Recommendation Report for Planning Permission**REF NO:** FP/179/11/**LOCATION:** 30 Limmer Lane
Bognor Regis**PROPOSAL:** Demolition of existing dwelling & outbuildings & erection of 6 no. apartments with associated parking & landscaping (re-submission following FP/182/10/)**SITE AND SURROUNDINGS**

Proposed Apartments
Proposed Elevations

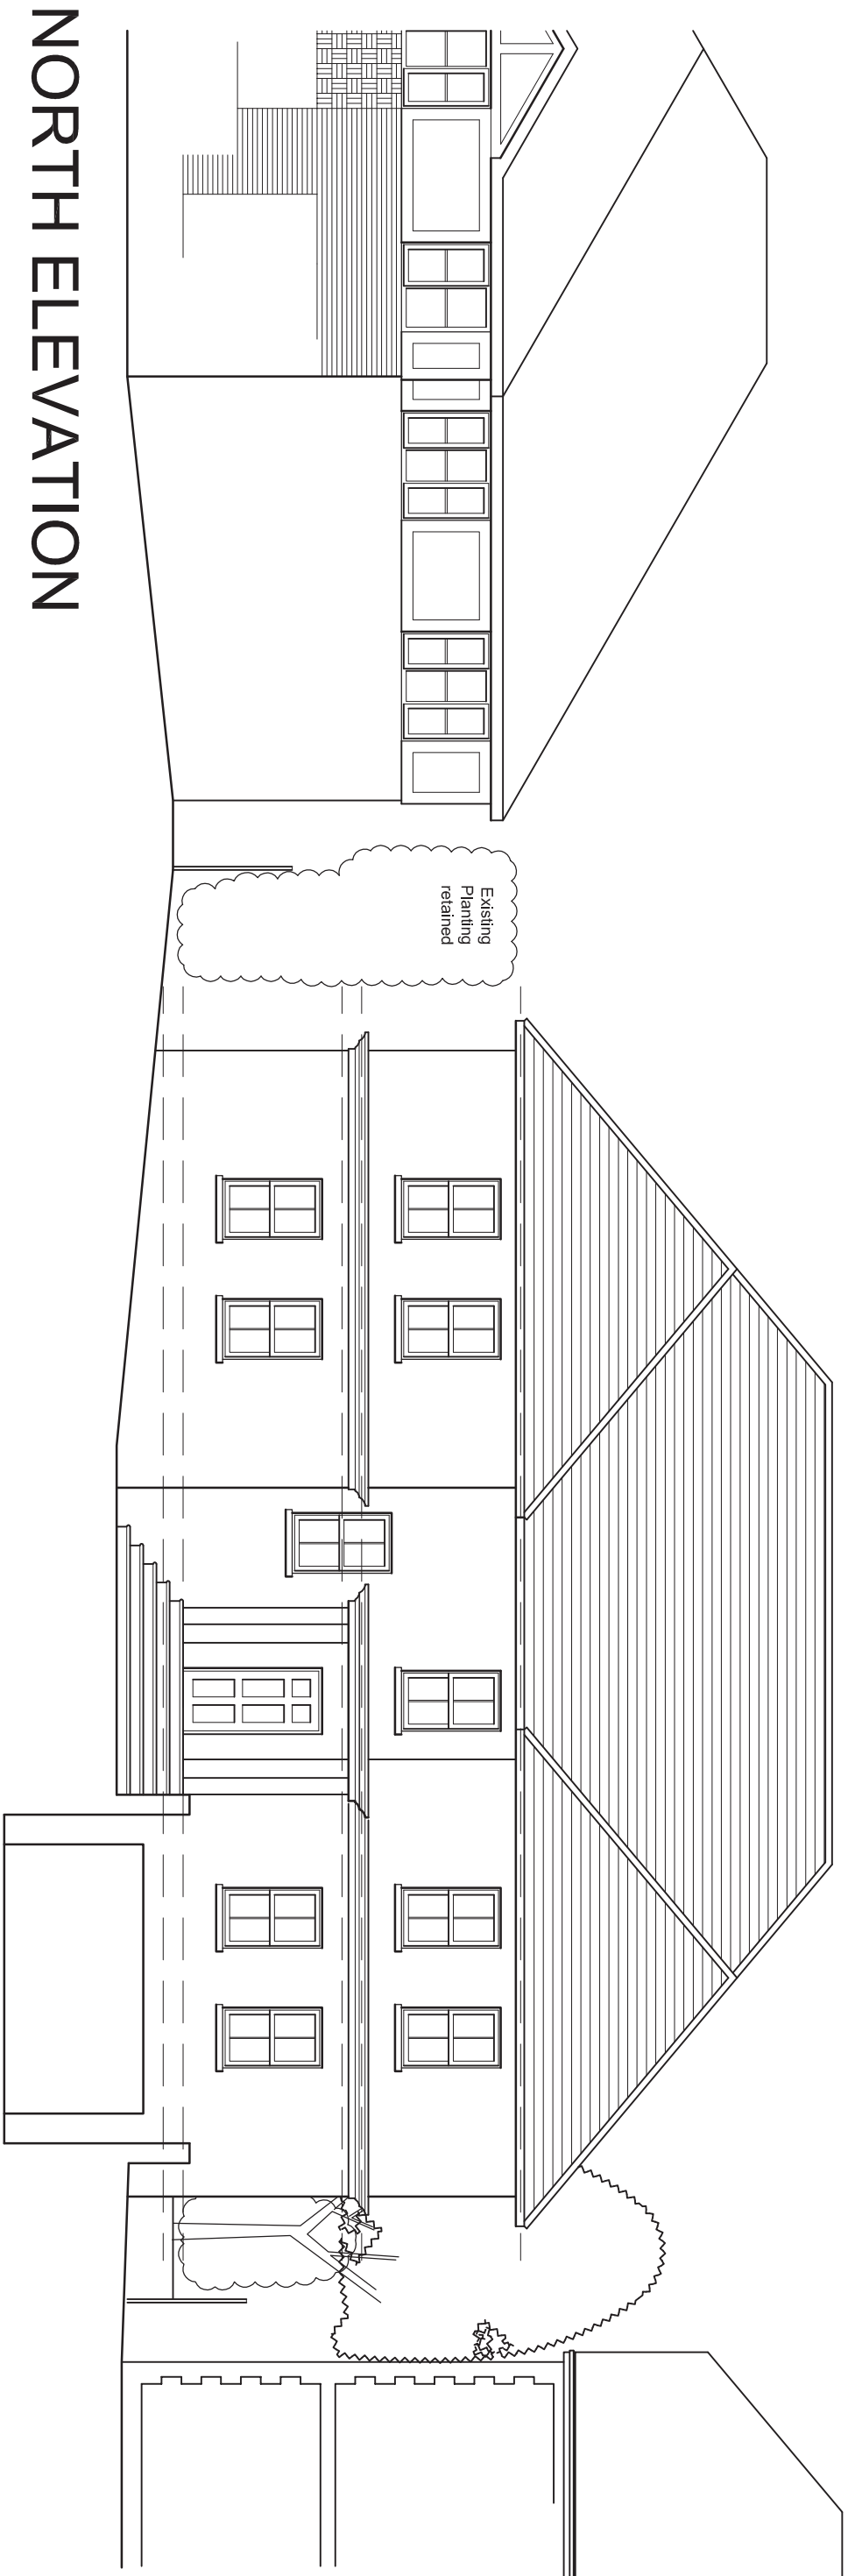
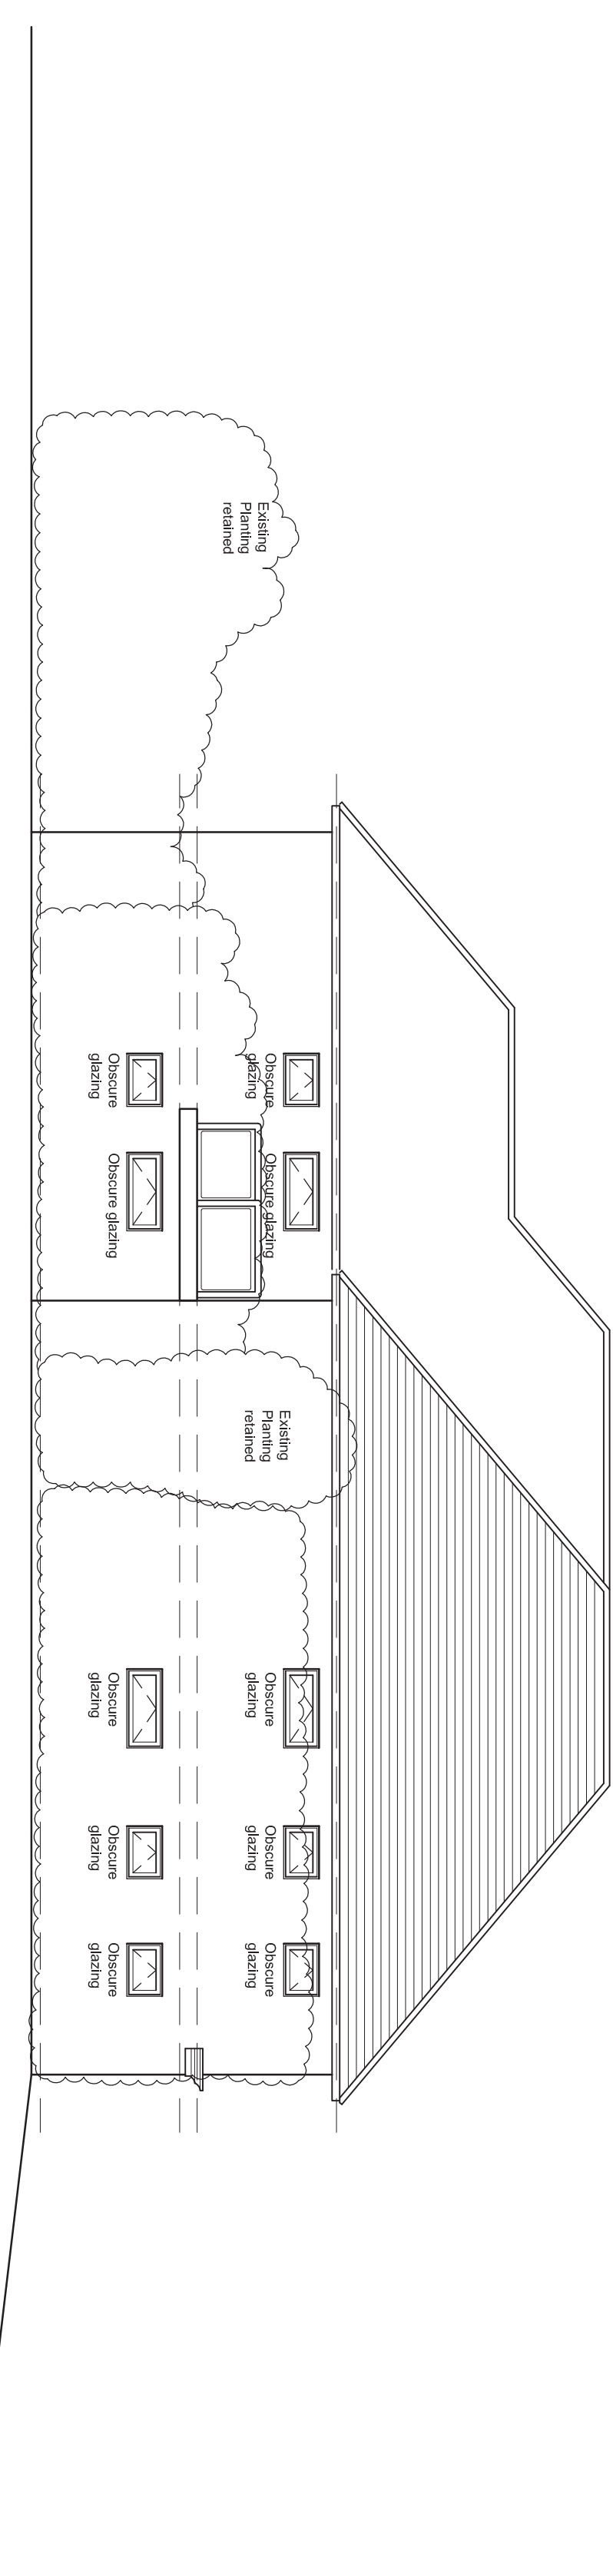
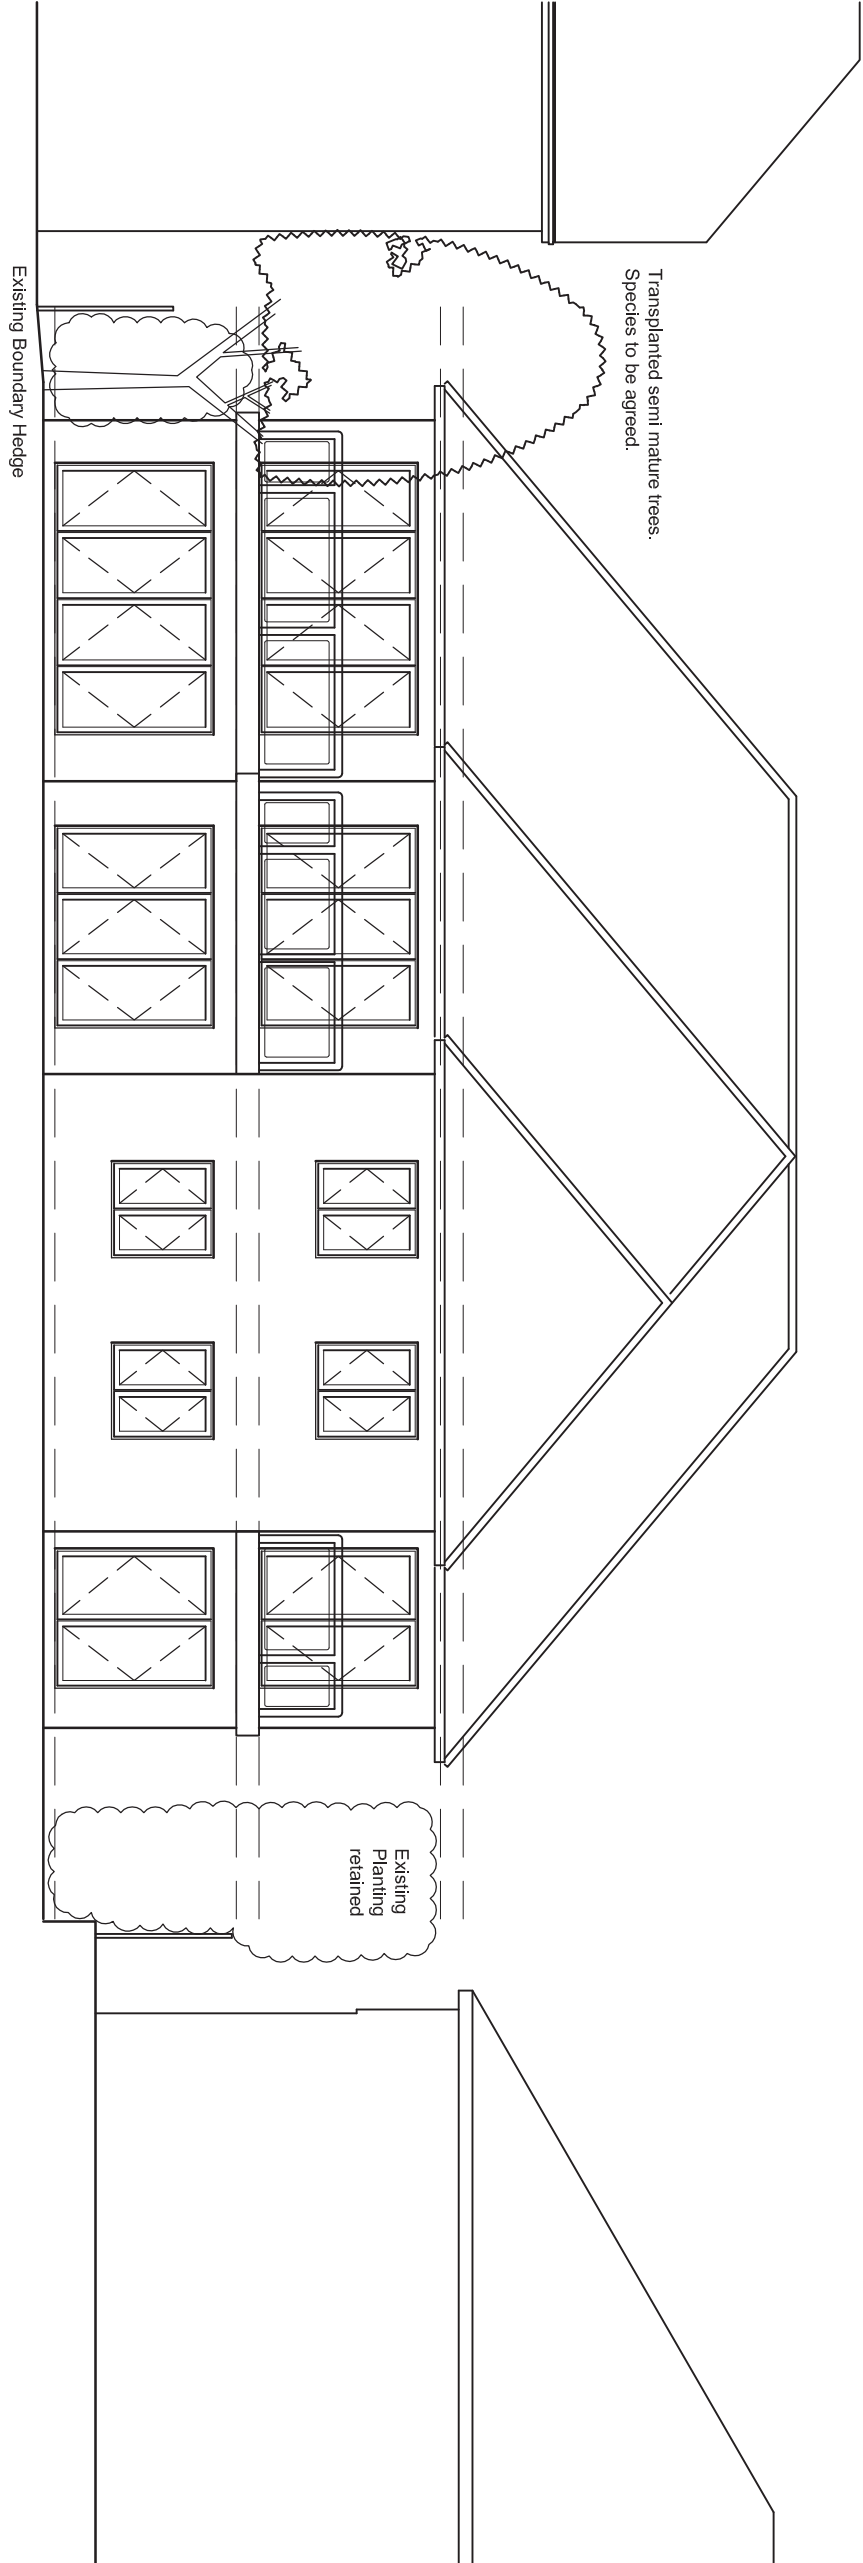
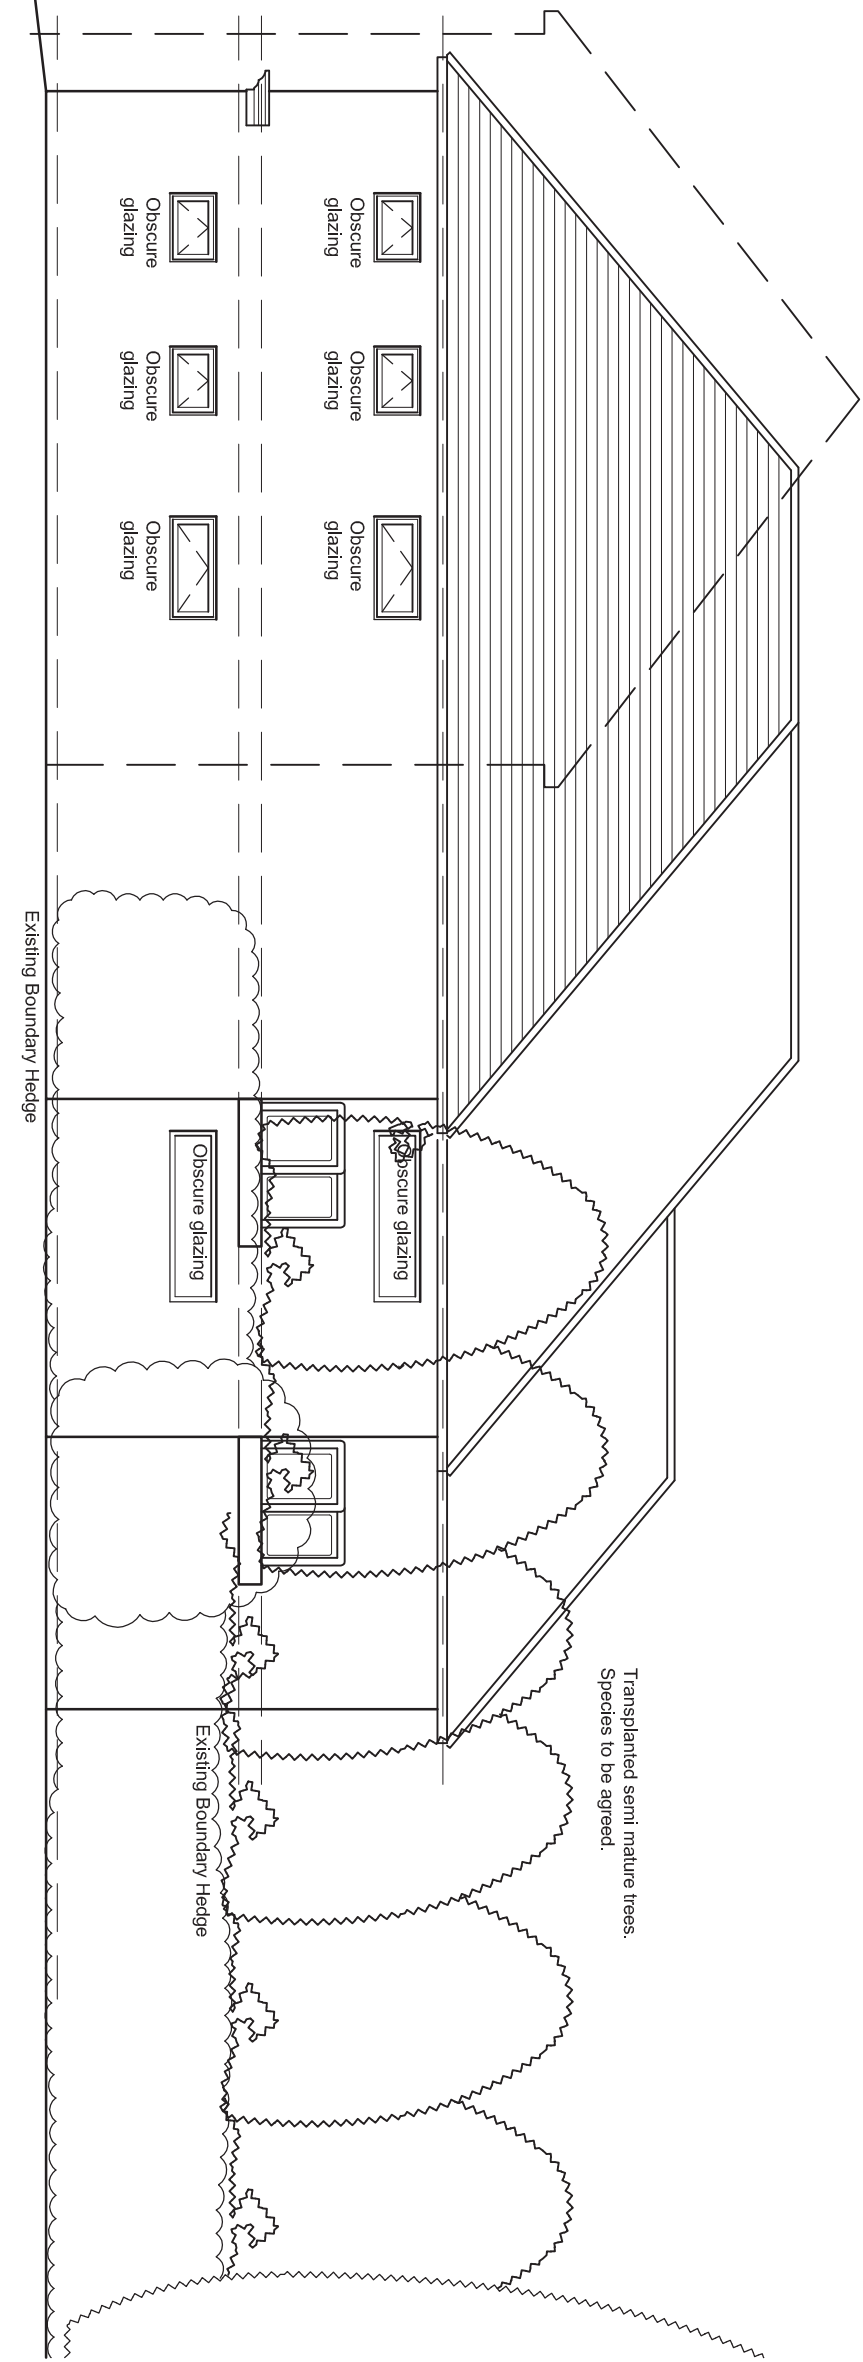
Would prefer to see central fenestration being symmetrical.

Elevations have been amended to incorporate symmetrical fenestration. Comments made by Landscape Officer are included in the landscaping conditions. An acceptable revised FRA has been submitted. There was a typographical error in the earlier stated existing floor levels.
